Application number: 2023/90444	
What is the application for?:	Erection of detached dwelling
Address of the site or building:	Land adj, Fern Bank, Far End Lane, Honley, Holmfirth, HD9 6NS
Postcode:	HD9 6RP

Type of comment: An objection	
Do you wish your comments to be published on the website anonymously?	Yes

North Elevation - 1:100

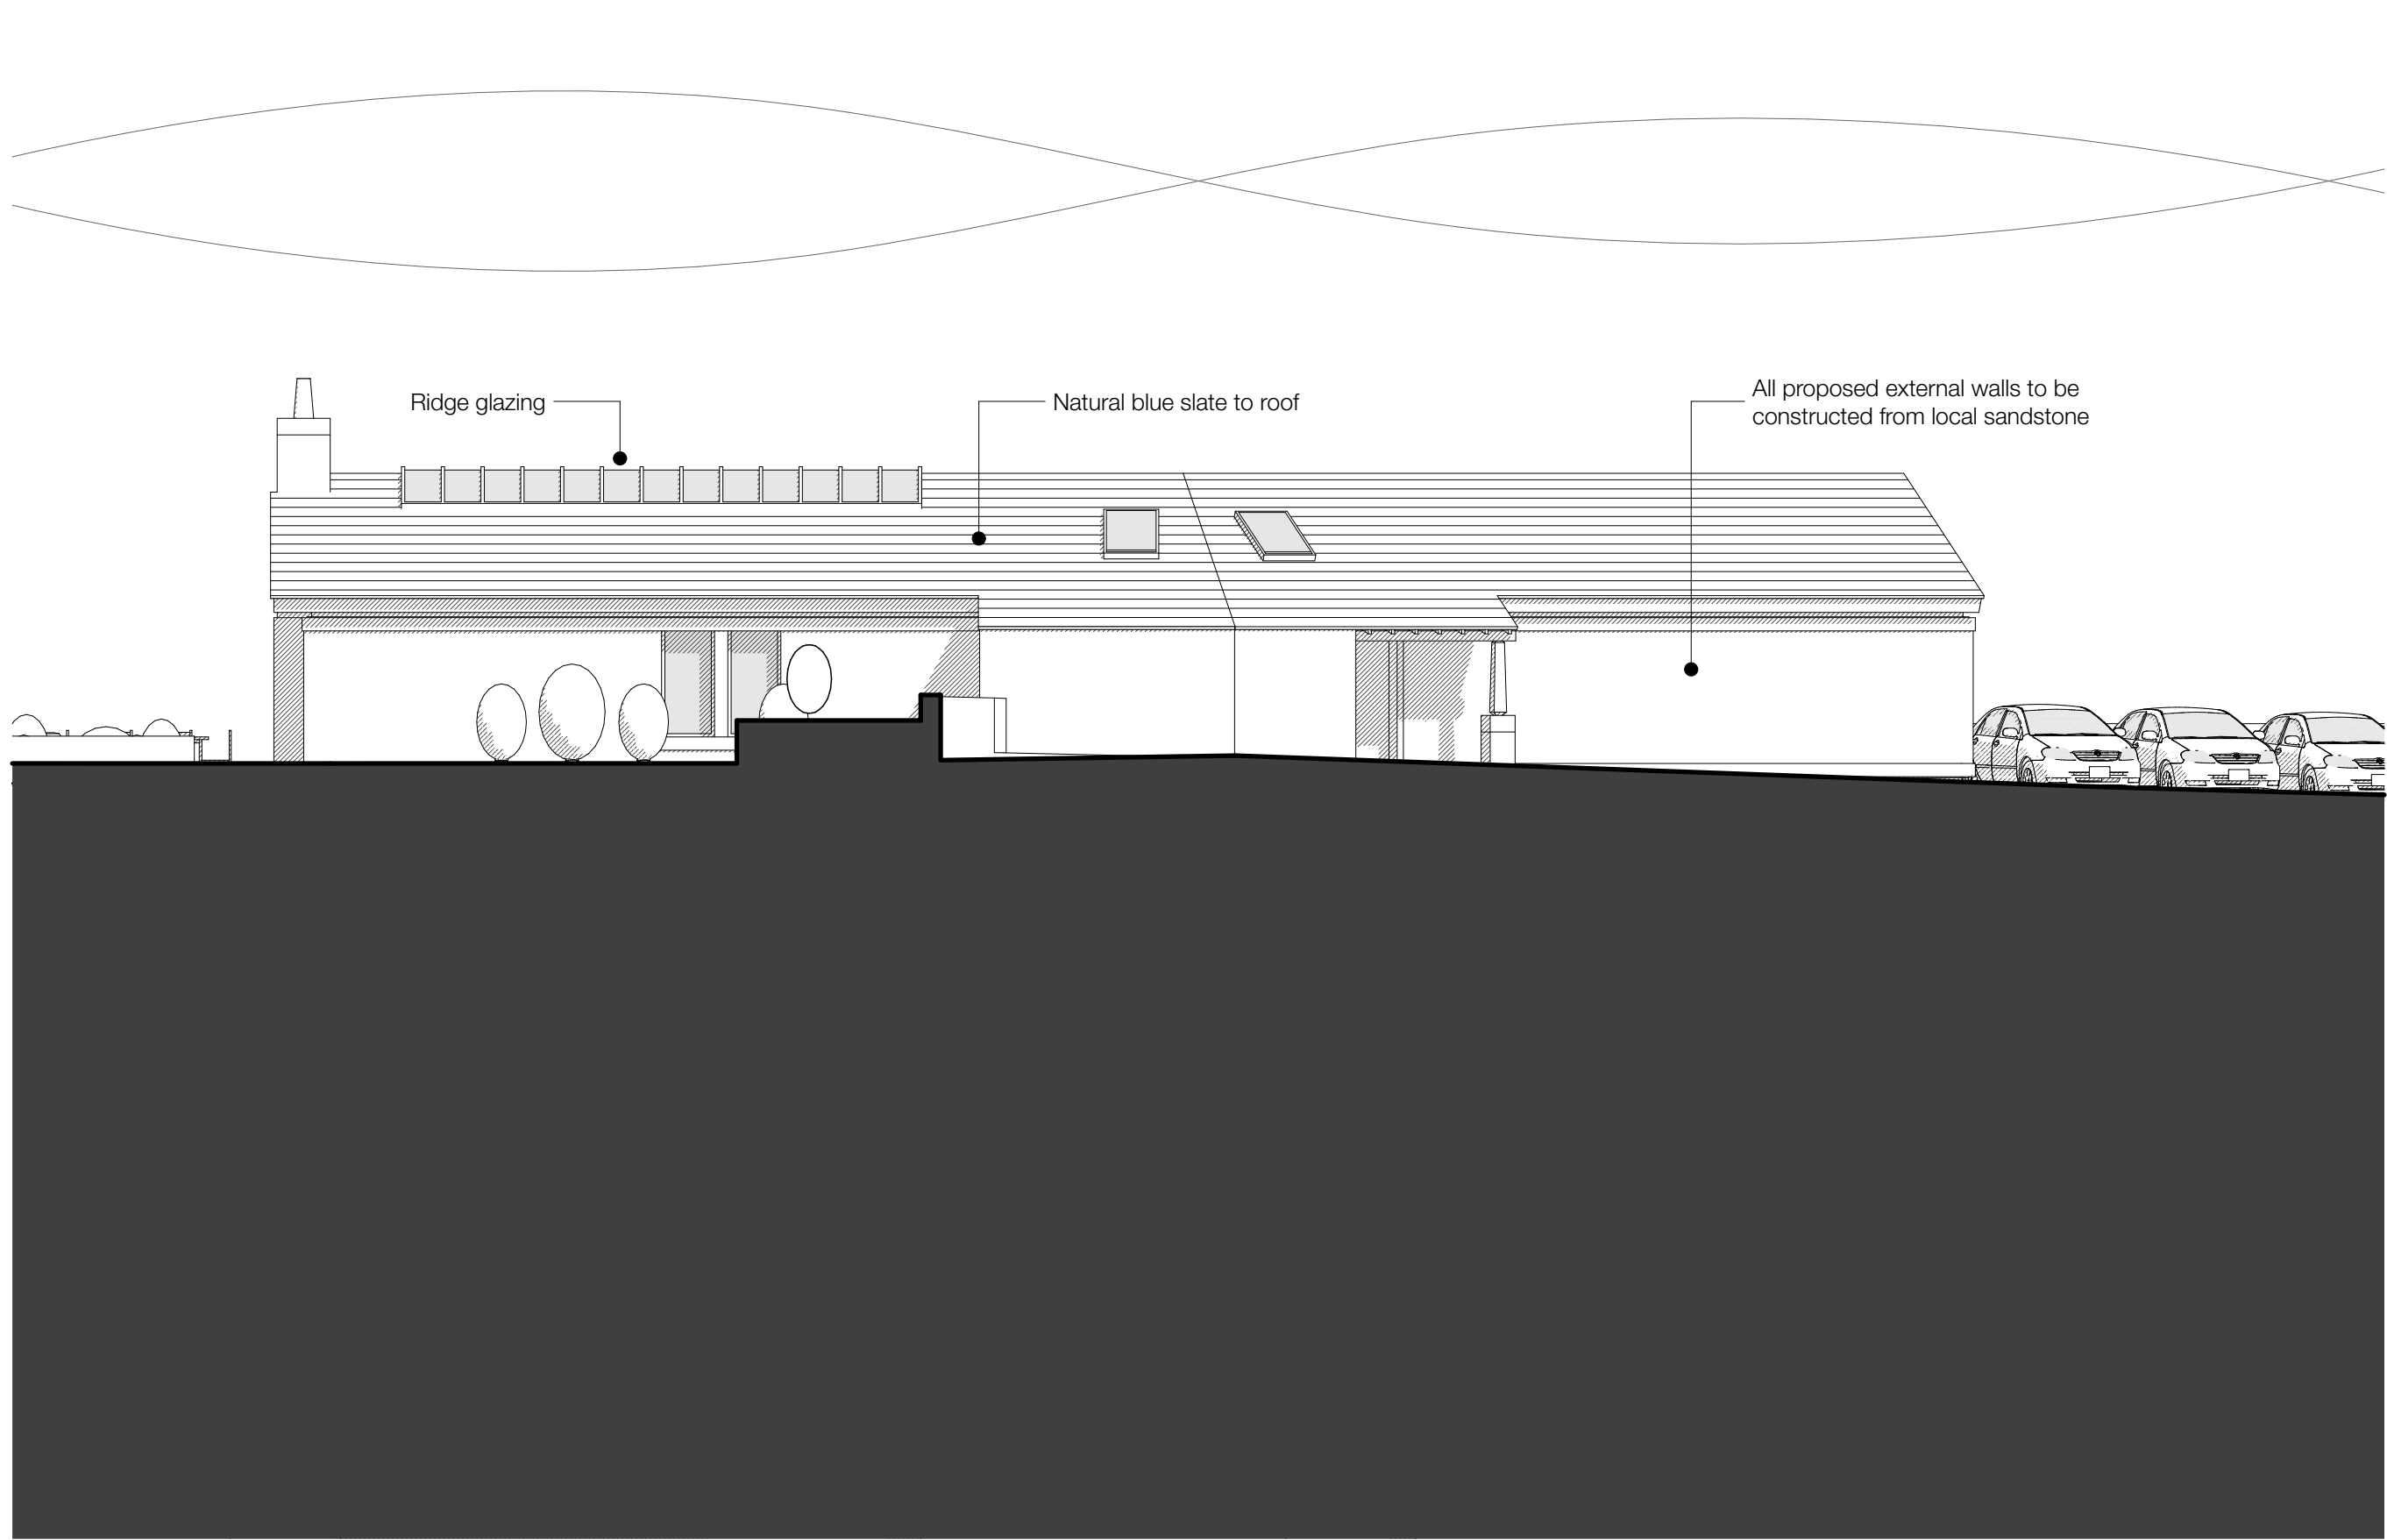
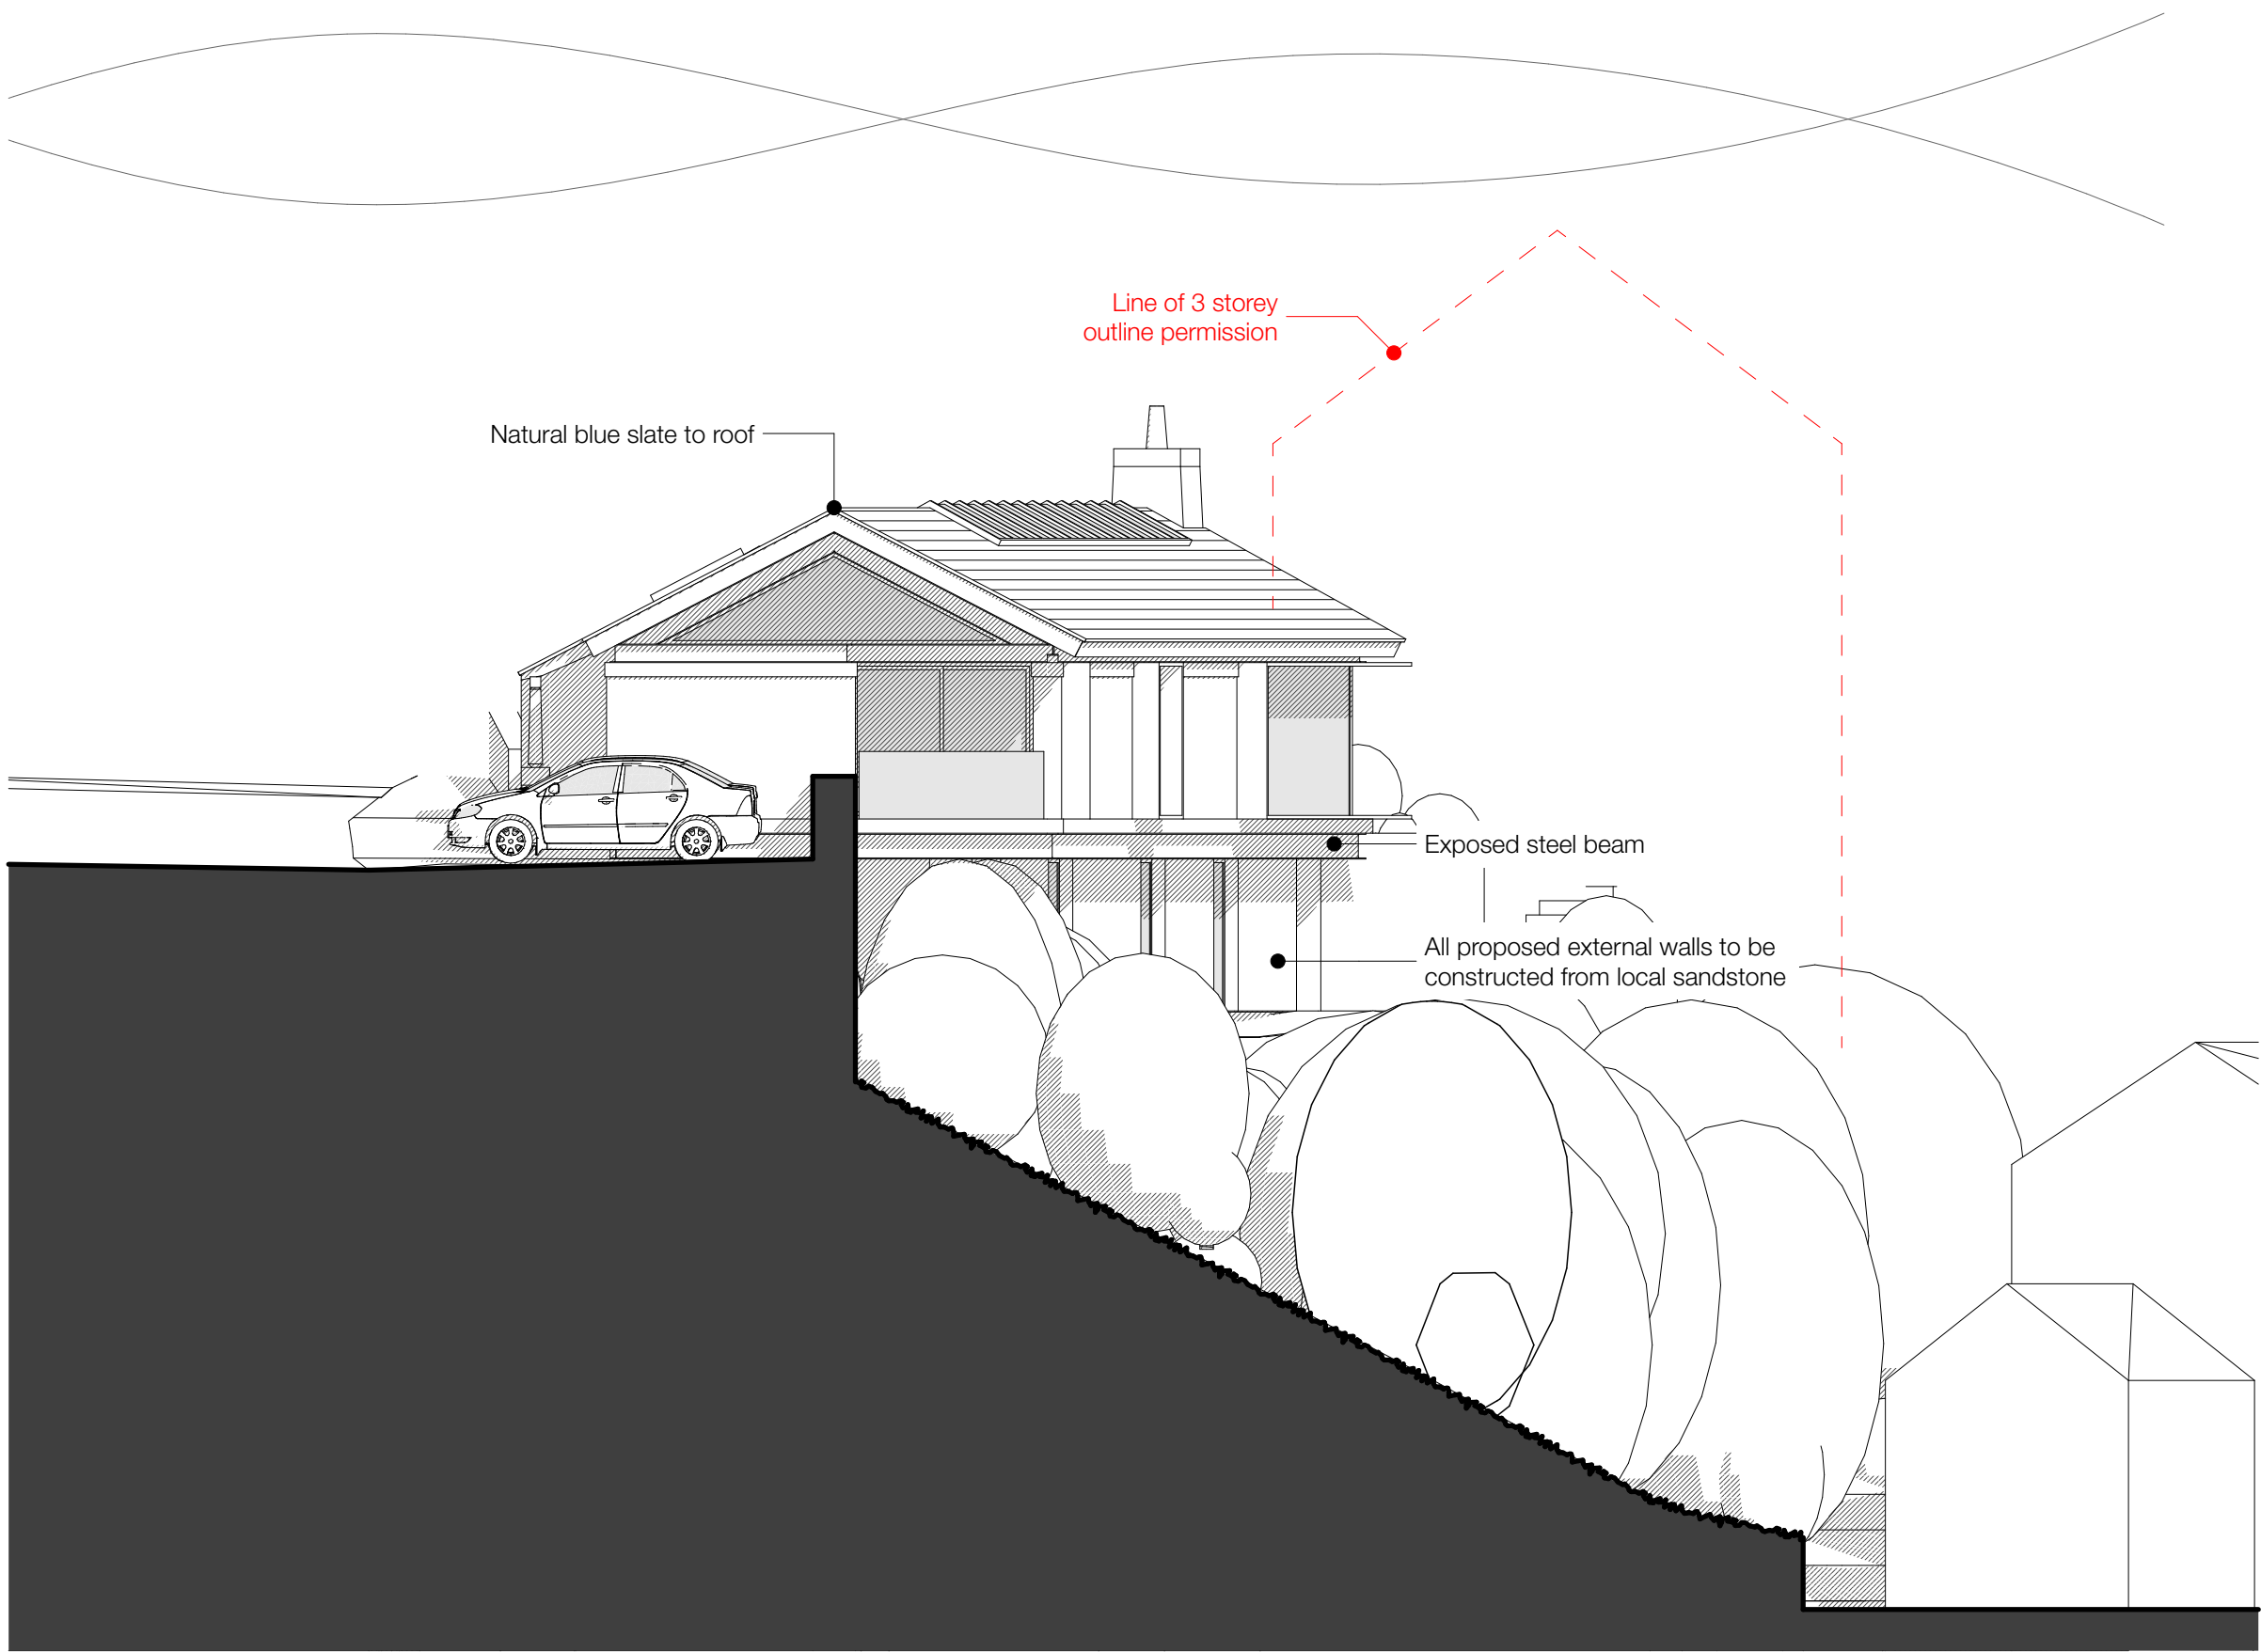
Outline Planning Permission - it has still not been explained why the footprint in this new application can differ so substantively from the Outline Planning Permission.
